Our Ref: R/283/19/PL

**Town & Country Planning Act 1990 (as amended)
Town and Country Planning (Development Management Procedure) (England) Order 2015
Application for Planning Permission**

Development InstaVolt are proposing to install two rapid electric vehicle charging stations within the grounds of Broadmark Lane, Rustington. An existing area will become two EV charging bays, along with associated equipment.

Location Broadmark Lane Rustington Littlehampton

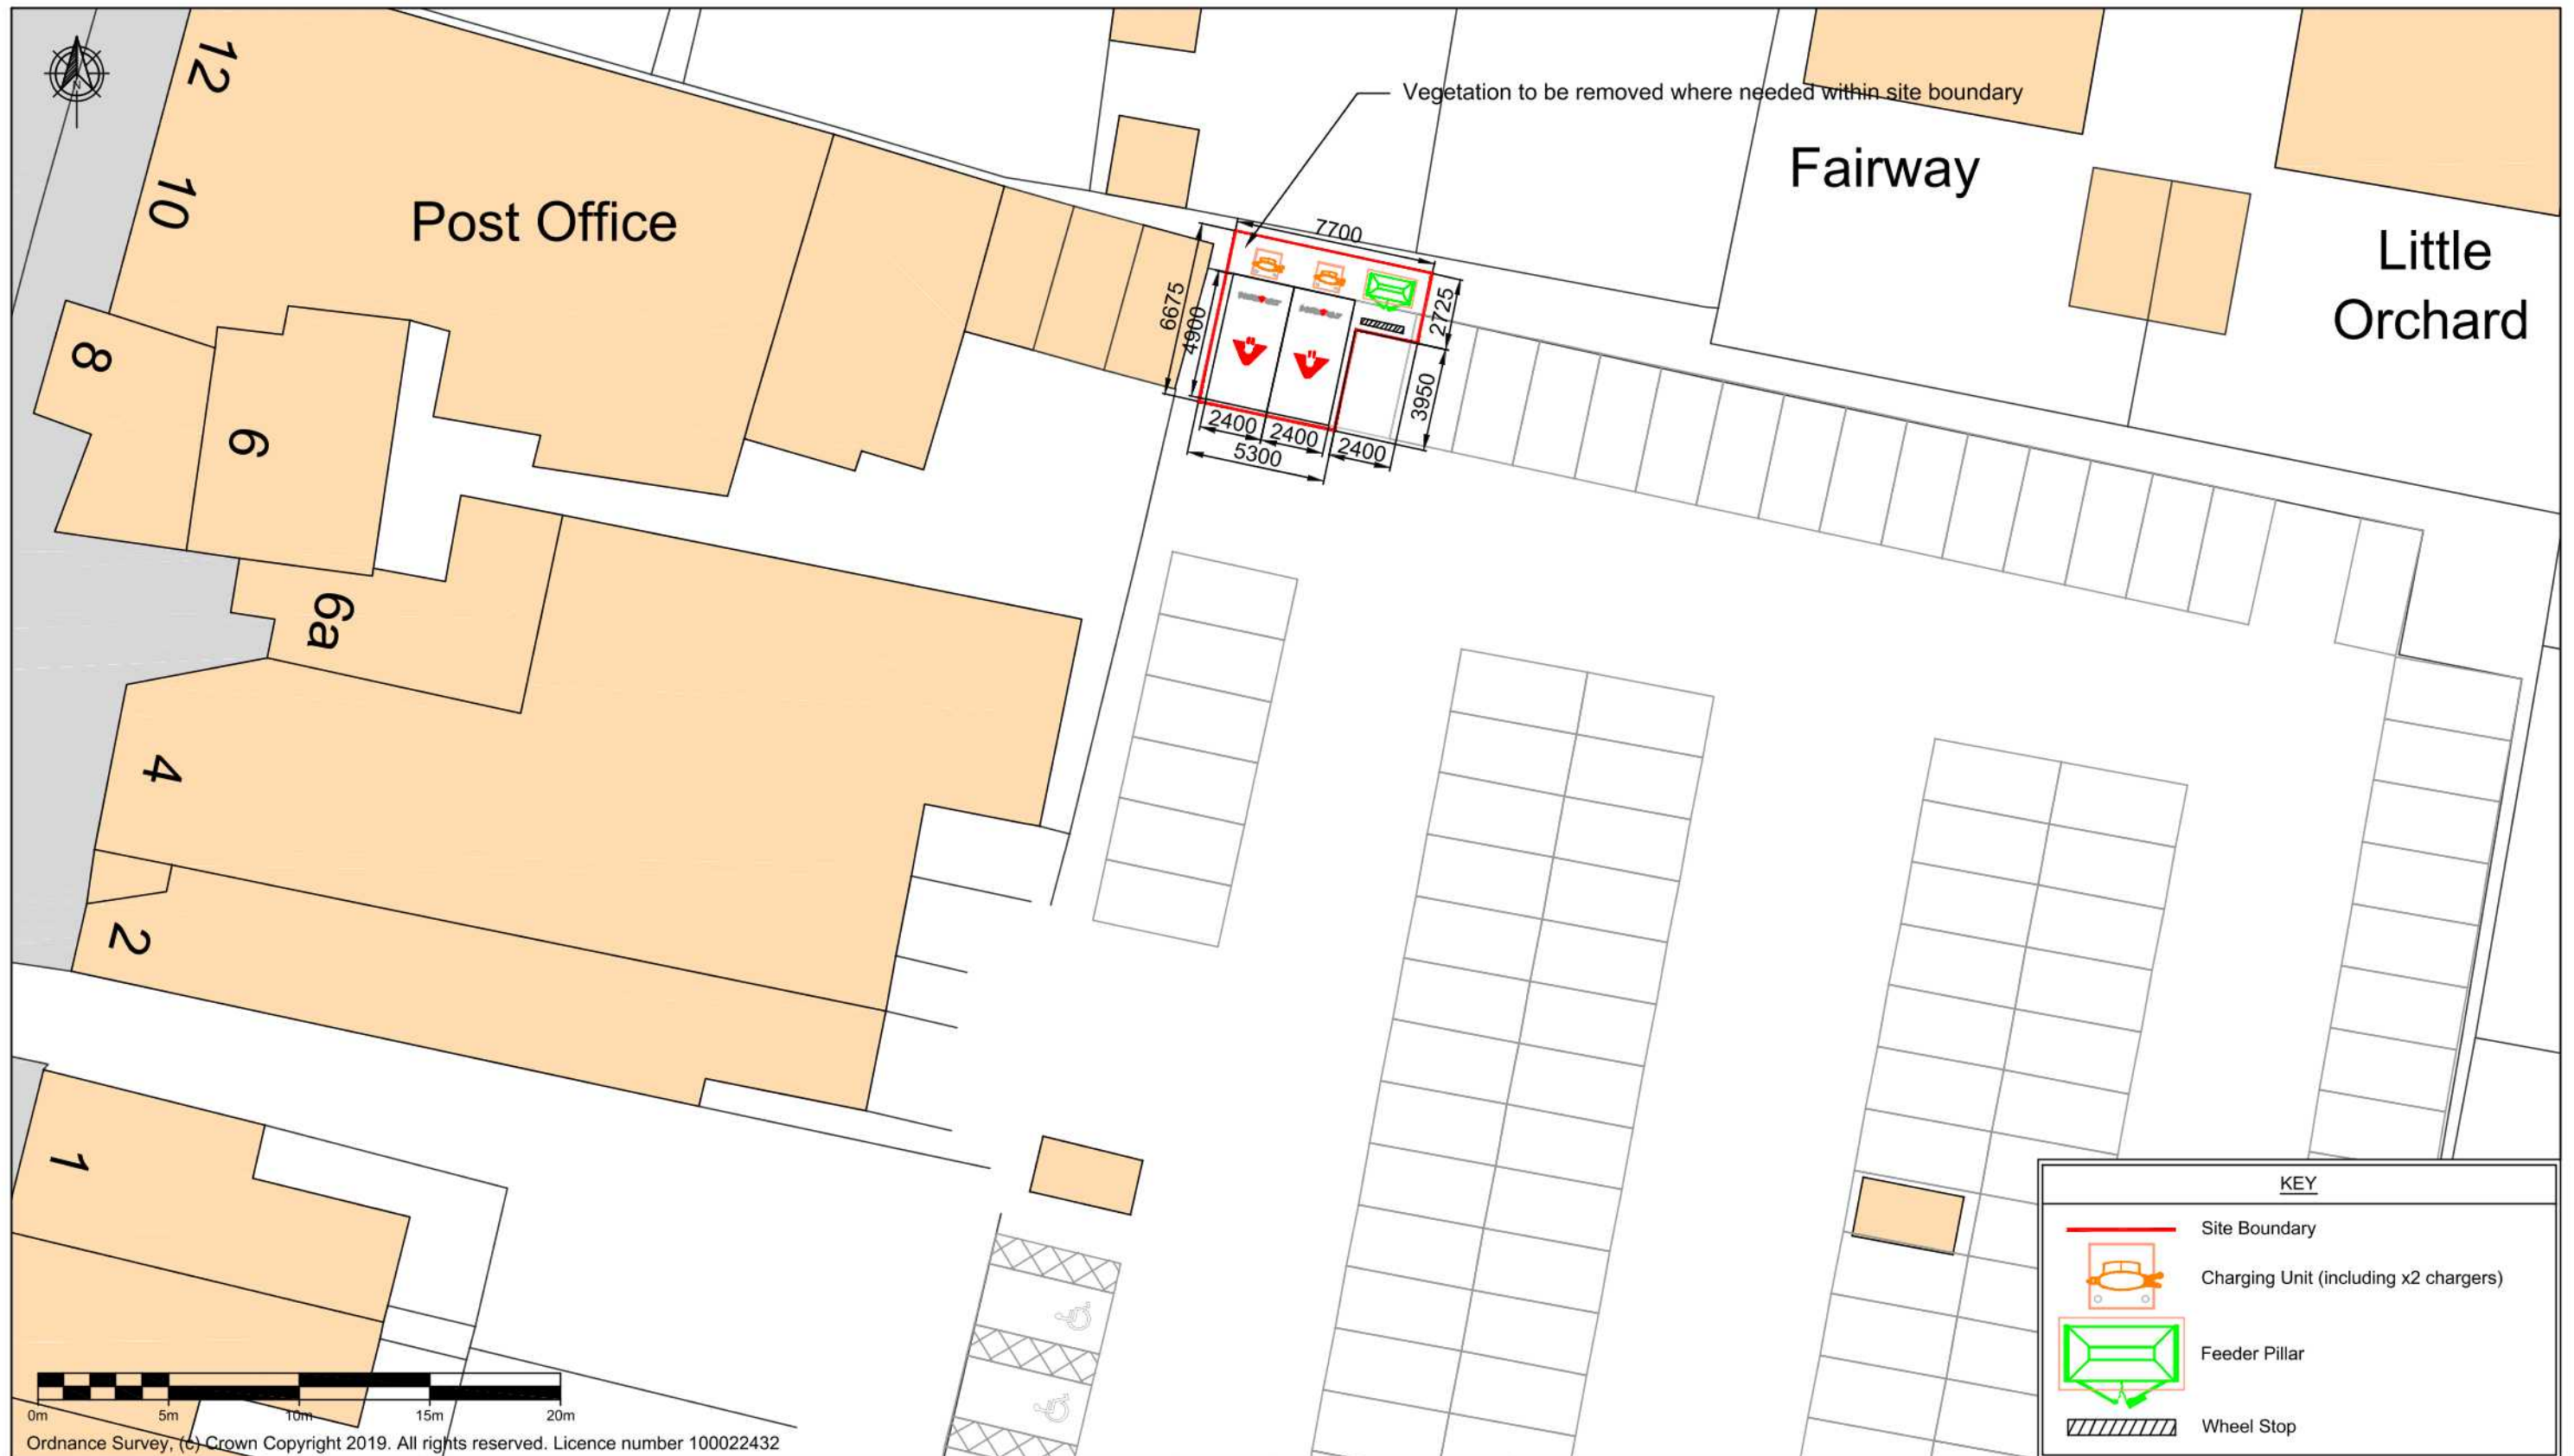
Address: The address cannot be 'Broadmark Lane' it will need to be 'Car park to the rear of 1-3 Broadmark Lane' please amend all forms and plans to this.

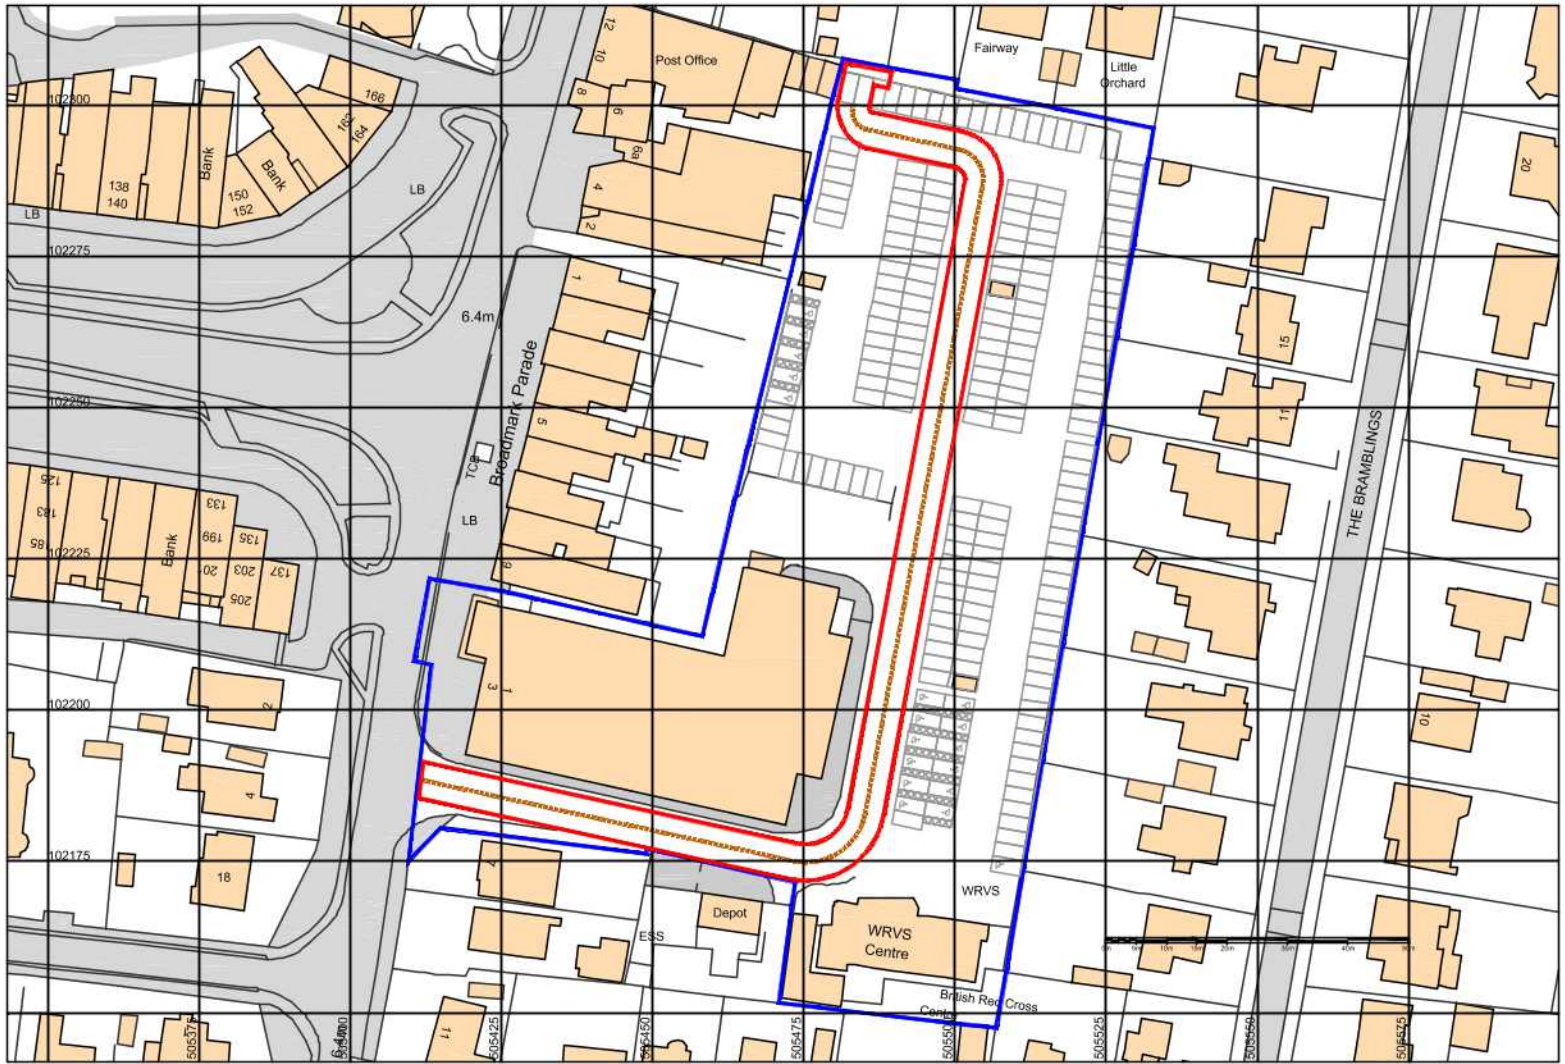
Access: Please include the access to the charging ports within the red outline on the location plan.
